14 June 2016

File No: R/2015/42/A
Your Ref: SSD 7382

RE: State Significant Development Application for UTS Central, Broadway Precinct, UTS City Campus, Ultimo (SSD 7382)

Approved Application No. **SS0 7382**
granted on the **23/09/16**
Signed **[Signature]**
Sheet No. **39** of **42**

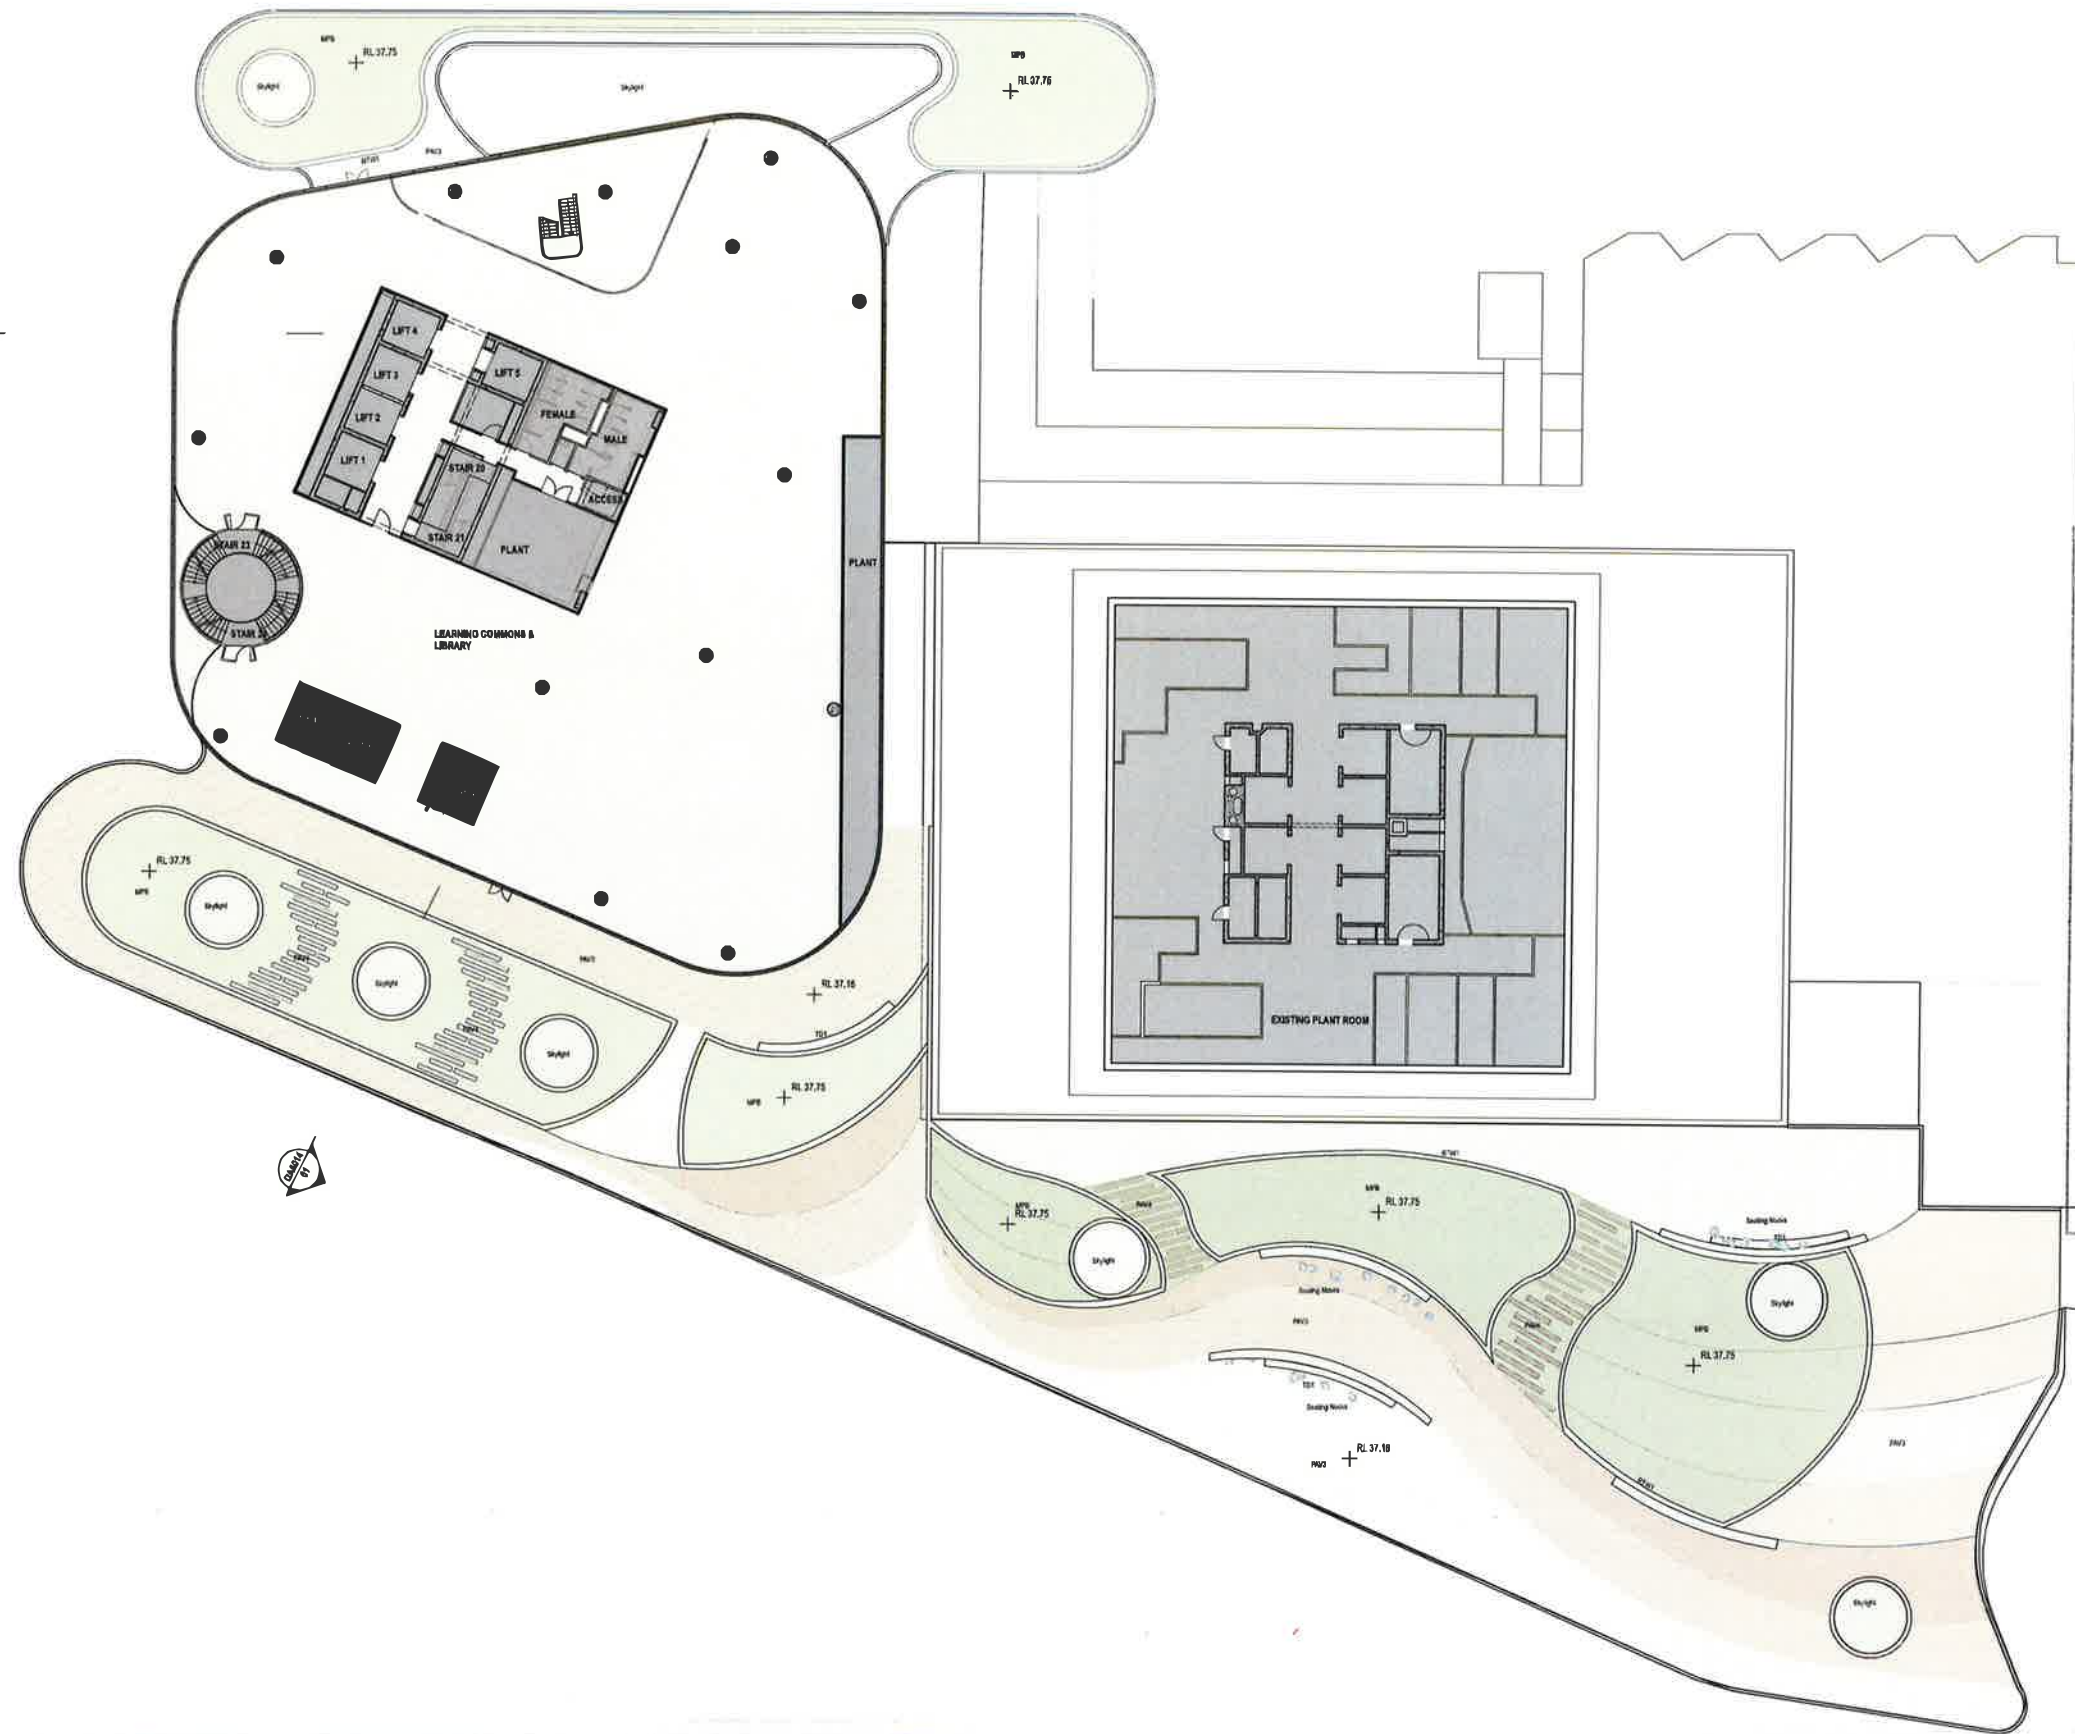
The northern roof terrace to Level 8 serves limited function. It is recommended the terrace be reconfigured to include seating areas, and that the large consolidated planter beds support some additional tree planting.

Soil depths must be confirmed to ensure a sustainable planting design. The option for a 'landscape designer' instead of 'landscape architect' should be removed. A detailed design for a development of this scale should be undertaken by a landscape architect.

04 PLAN Landscape Section Jones Street 1:150

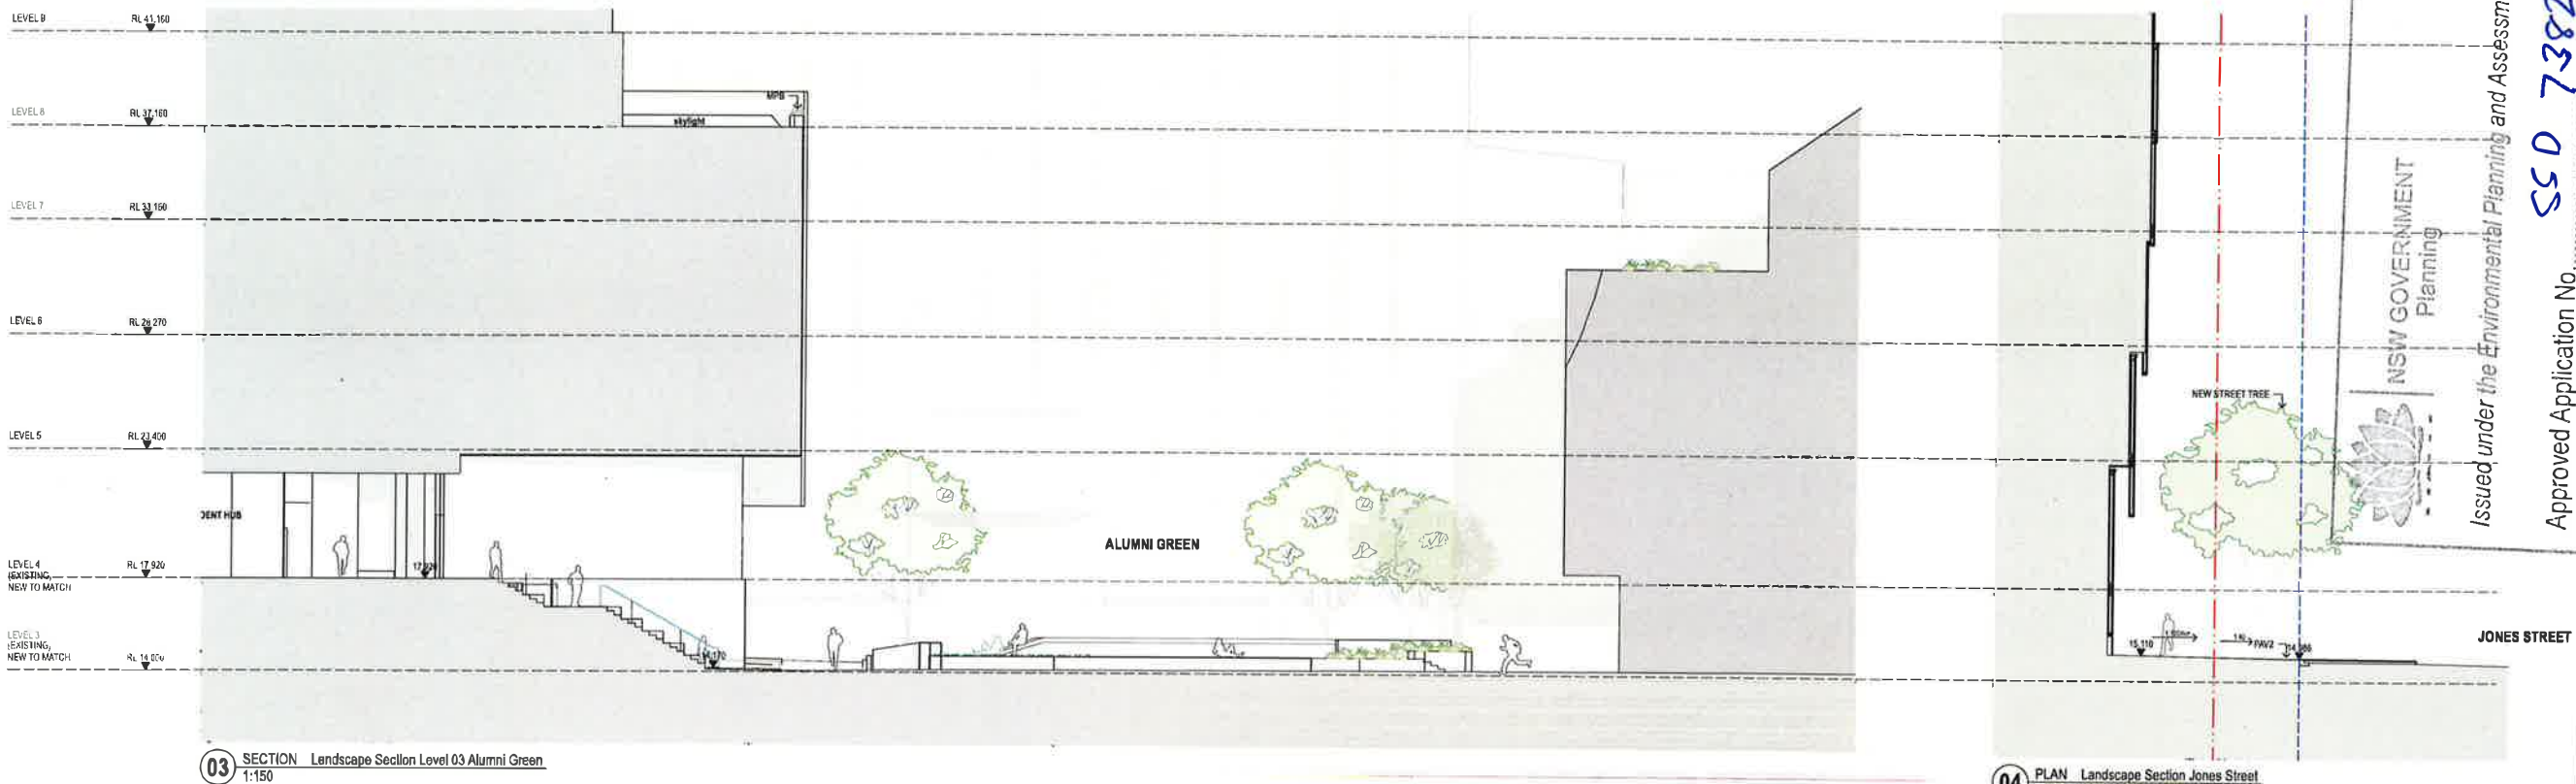
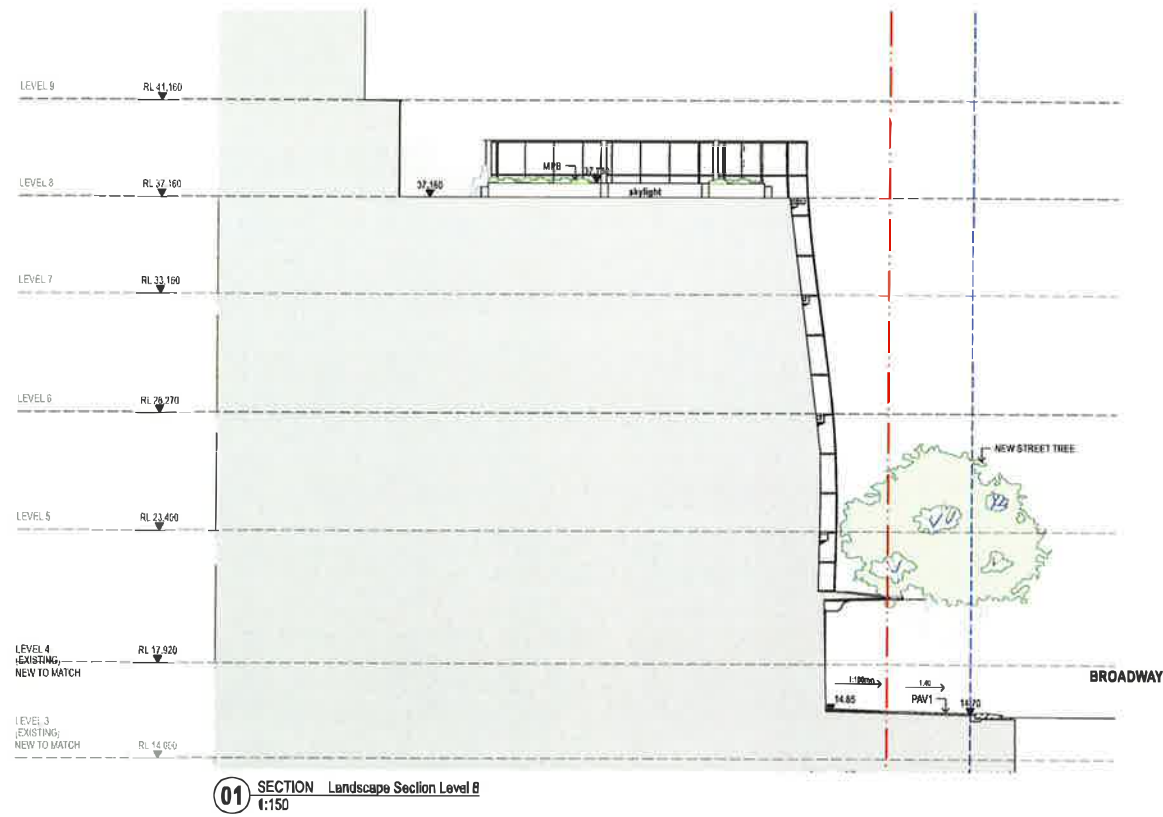
The paving pattern shown on the general arrangement plan mirrors the shape of the building along Jones Street. The proposal appears to include multiple paving types or finishes. As this is partly on City land the proponent will require approval from the Council as part of their Public Domain Plan.

Landscape Plans indicate new street tree planting along Broadway and Jones Street. The plans include species which are consistent with the City's Street Tree Master Plan (STMP). However, no detailed drawings have been provided demonstrating that new trees will be planted in accordance with the STMP. Accordingly, detailed plans should be submitted for consideration.
